**KIRKLEES METROPOLITAN COUNCIL
INVESTMENT & REGENERATION SERVICE**

**DELEGATED DECISION FOR APPLICATION FOR CERTIFICATE OF
LAWFUL DEVELOPMENT**

Reference no.: 2021/CL/91394/W

Site: 30 , Varley Road, Slaithwaite, Huddersfield, HD7
5HL

Proposed Plans & Elevations

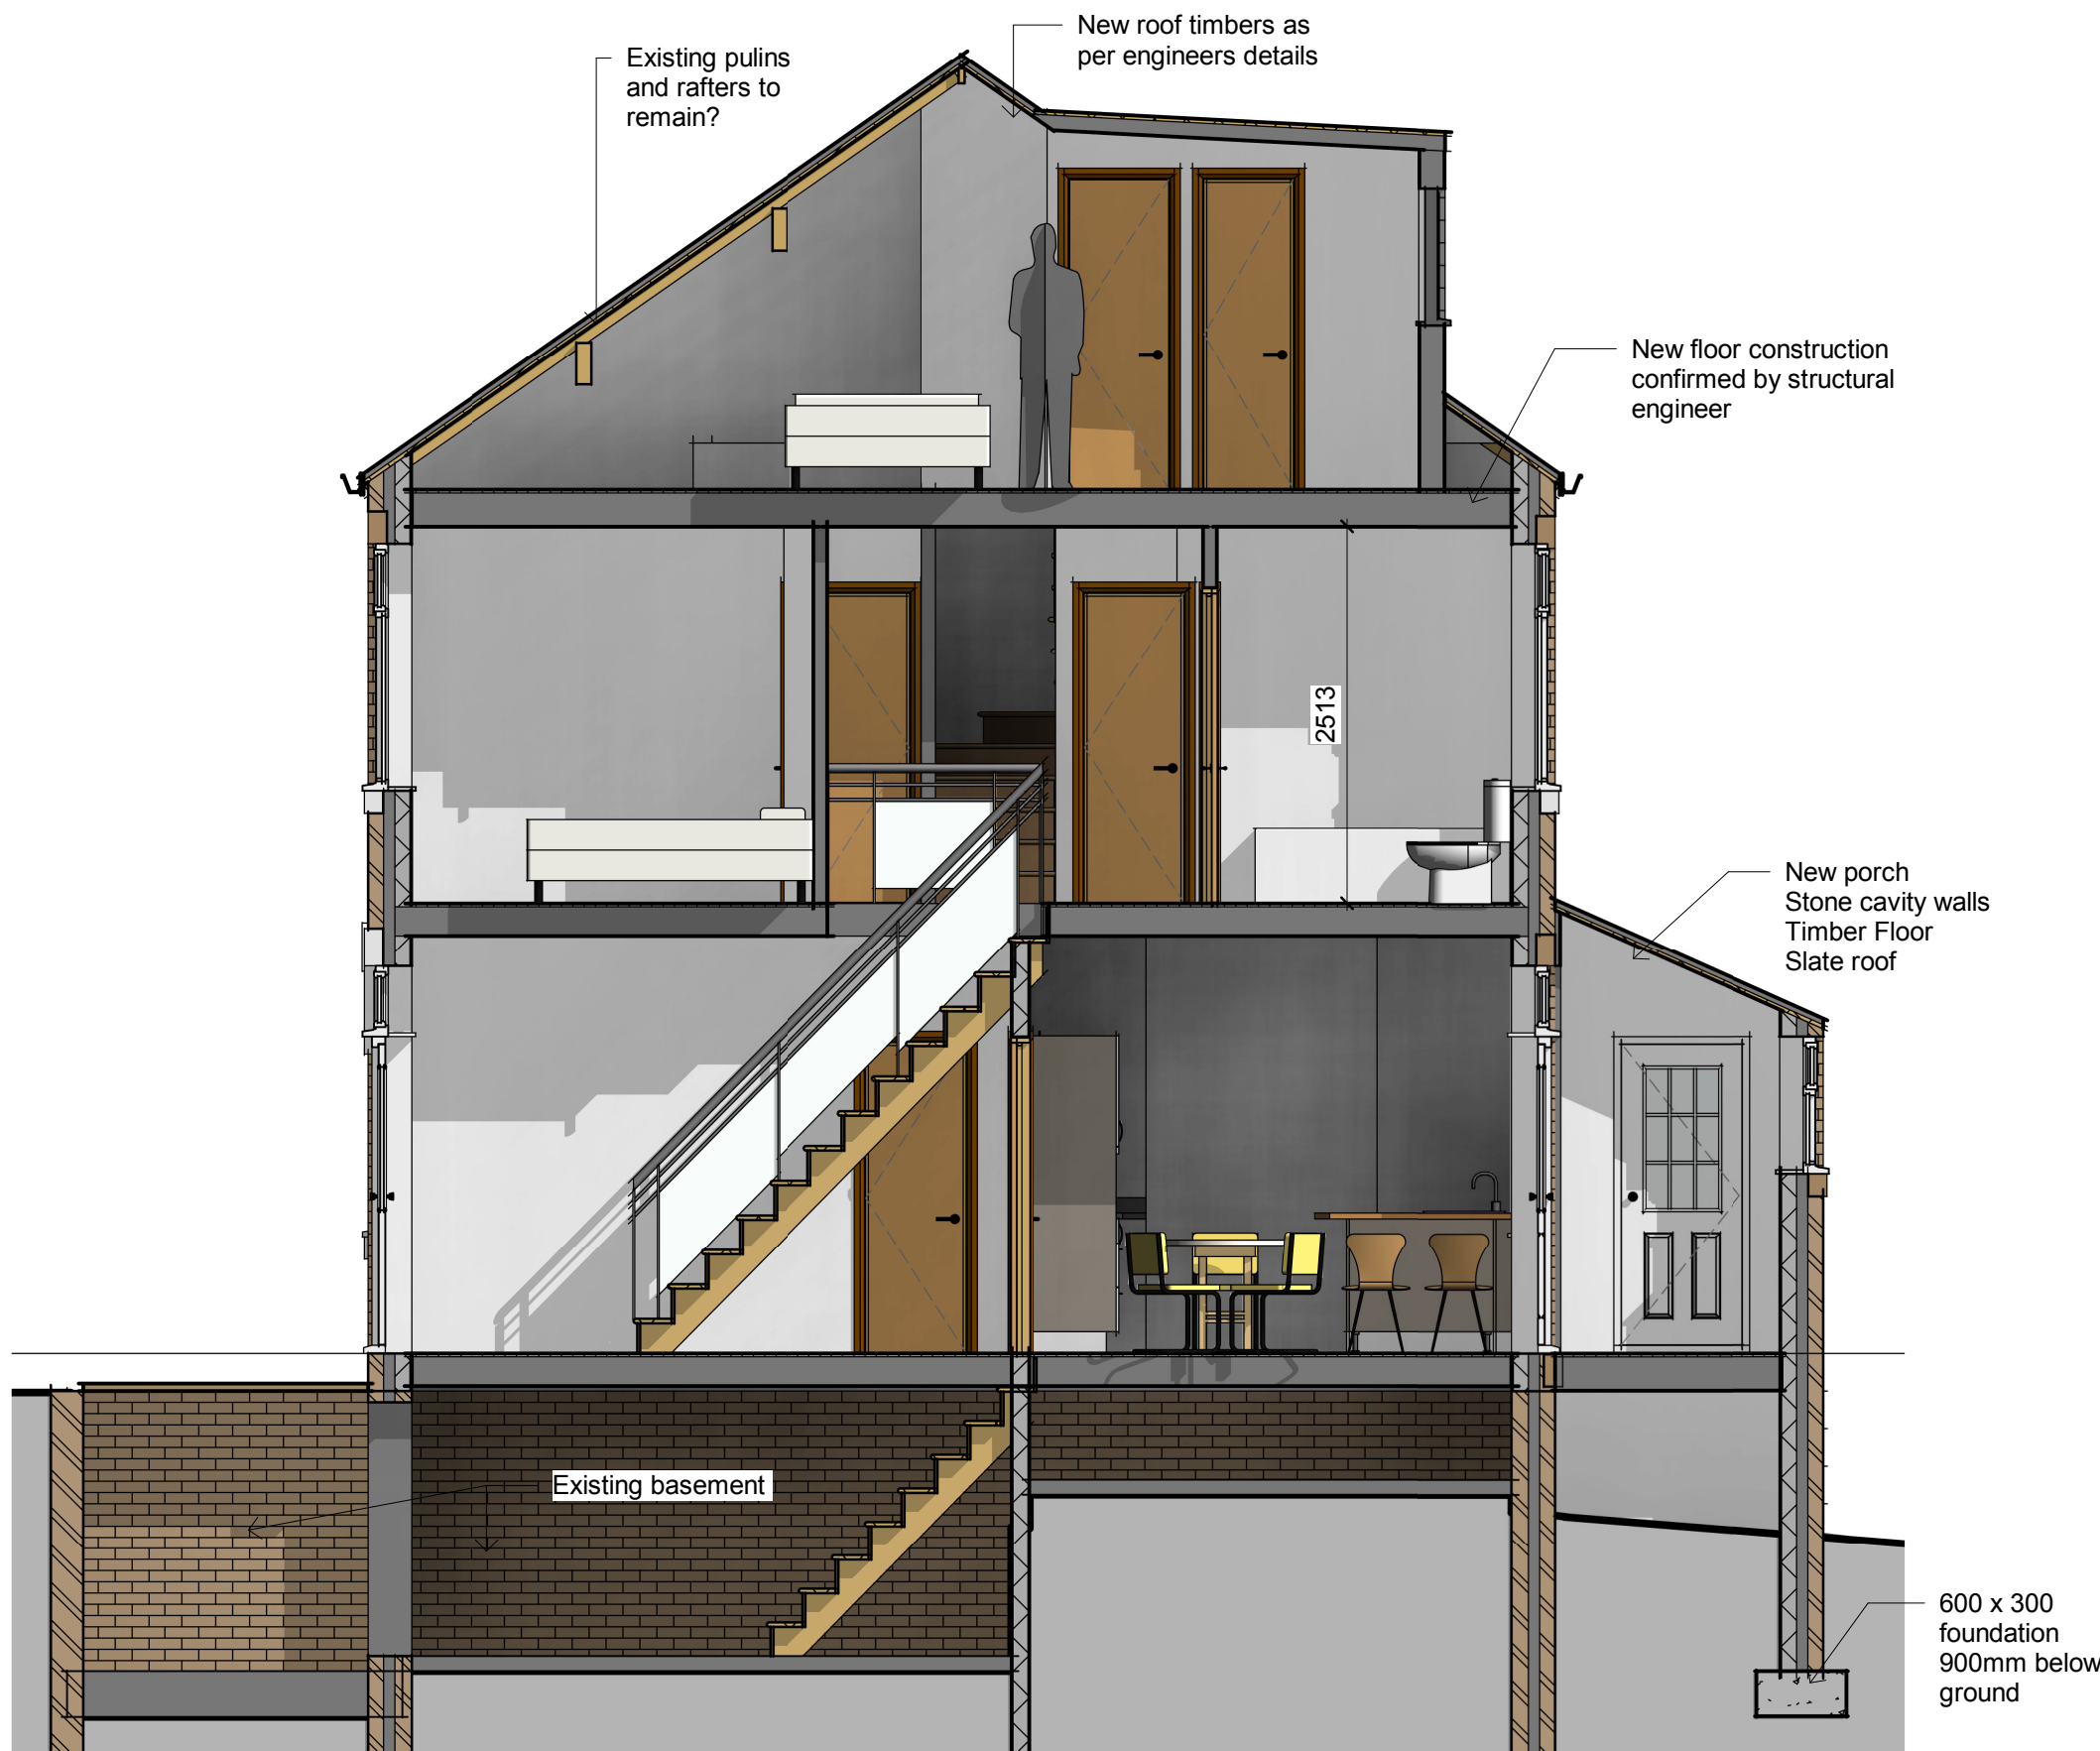
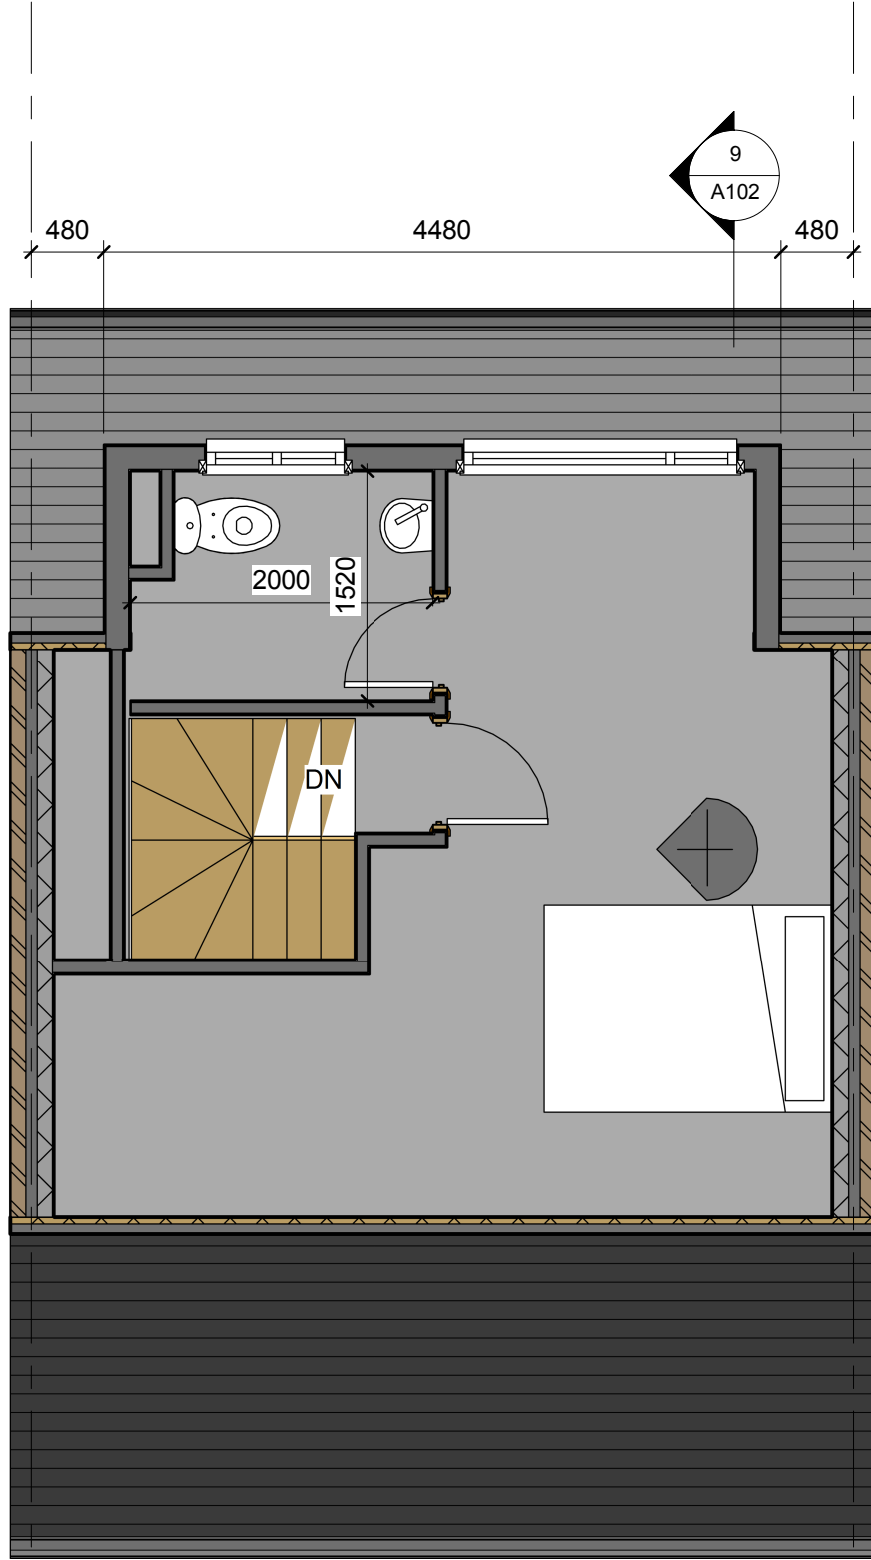
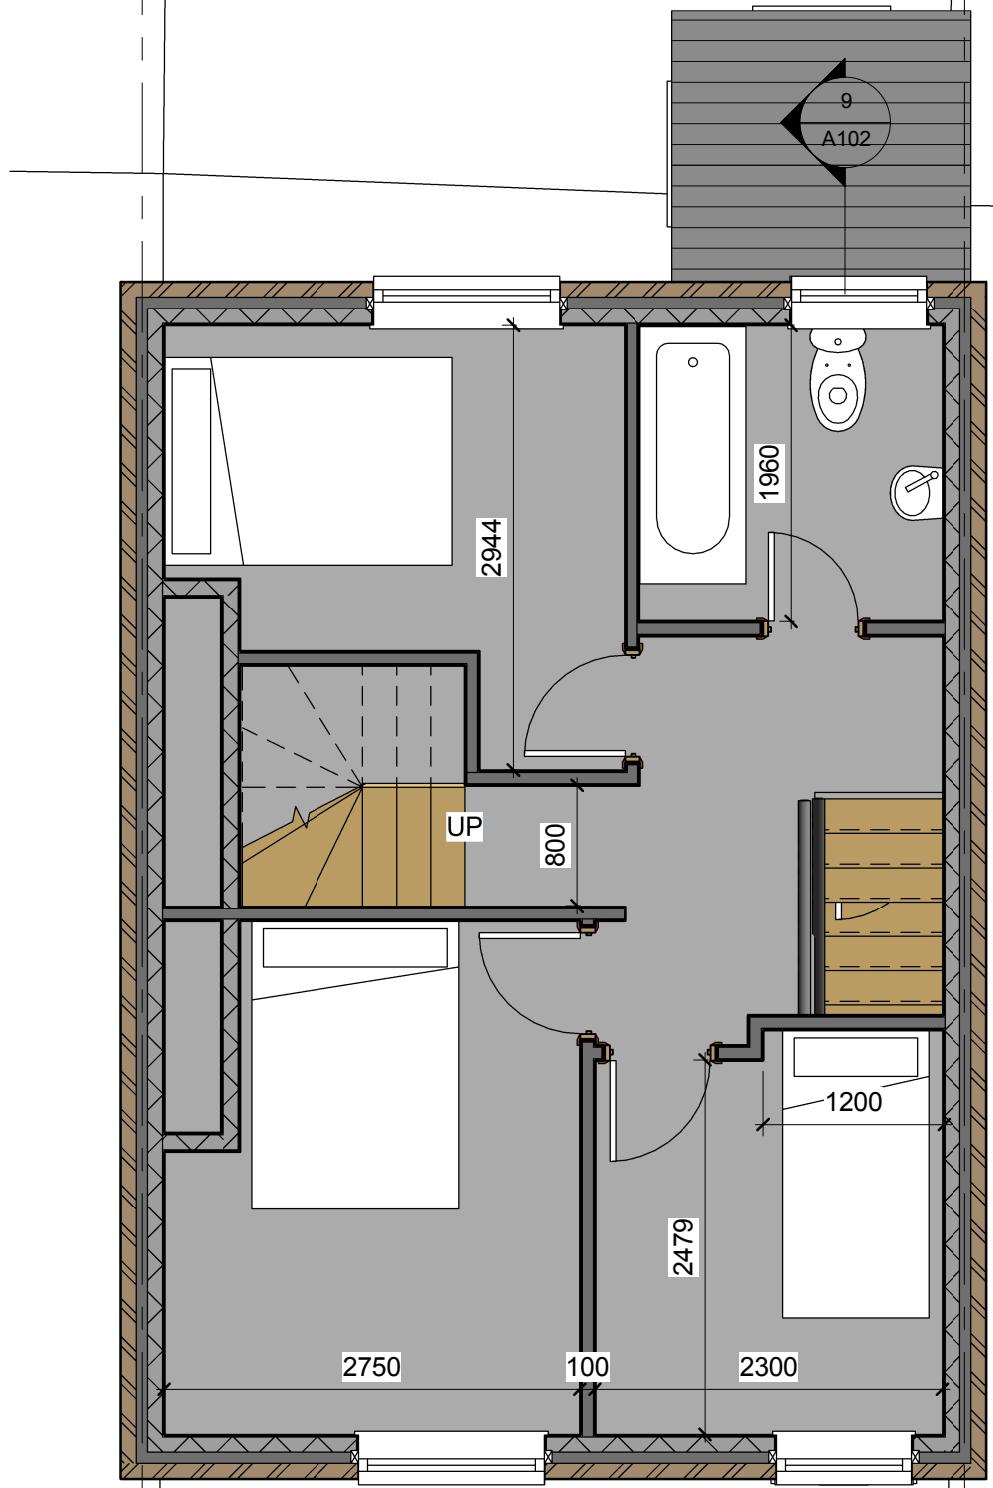
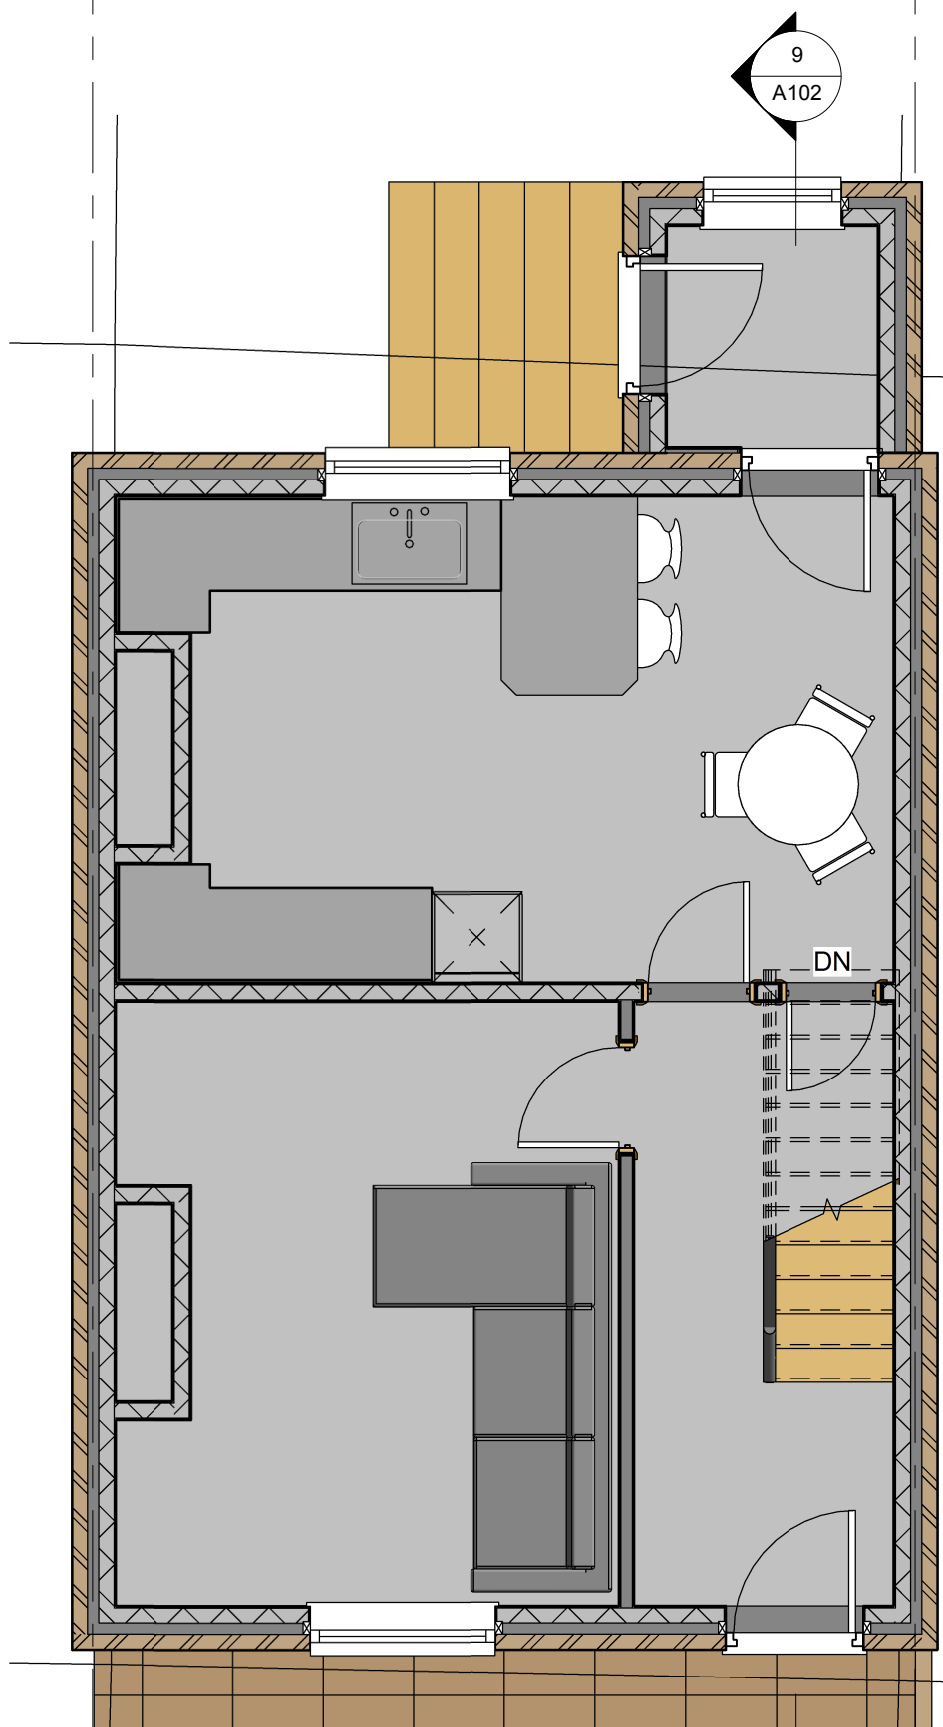
The development also proposes a 1.5 storey rear porch to be erected. It would project from the rear elevation by 1.74m and have a width of 1.94m. The lean-to roof ridge height would be 4.23m and eave height of 3.43m from the rear ground level.

Fail: It will exceed the limit of 4m above ground level.

Fail: It would have a ground level to eaves height of 3.43m and is within 2 metres of the boundary.

Fail: It would include raised platforms, i.e. steps

The rear extension(porch) does not benefit from a general planning permission granted under Schedule 2, Part 1, Class A of the Town and Country Planning (General Permitted Development)(England) Order 2015 (as amended) by reason of the height exceeding 4 metres and eaves exceeding 3 metres above ground level contrary to paragraphs (f) and (i) of Class A.

The rear extension(porch) does not benefit from a general planning permission granted under Schedule 2, Part 1, Class A of the Town and Country Planning (General Permitted Development)(England) Order 2015 (as amended) by reason of the height exceeding 4 metres and eaves exceeding 3 metres above ground level contrary to paragraphs (f) and (i) of Class A.

The development proposed is the erection of a roof dormer on the rear roof slope. The dormer is 4.48m wide, is set back from the side elevations by 0.48m each side, set back from eaves by 0.5m and set down from the roof ridge height by 0.34m and utilises the existing roof space to create an additional bedroom and ensuite accessed via an internal staircase. Two openings serving the bedroom overlook the rear garden of the terraced dwelling and green open space to the rear.

A flat roof dormer of these dimensions has been assessed as being approximately 11 cubic metres in volume.

As stated above the roof space of the property has not been previously enlarged and the total resulting roof space would increase the original roof space by approximately 11 cubic metres and therefore within the above limitation.

The proposed roof enlargement would be permitted development as set out in Schedule 2, Part 1, Class B of the Town and Country Planning (General Permitted Development)(England) Order 2015(as amended) subject to conditions as stated in paragraph B.2 of the same Order.
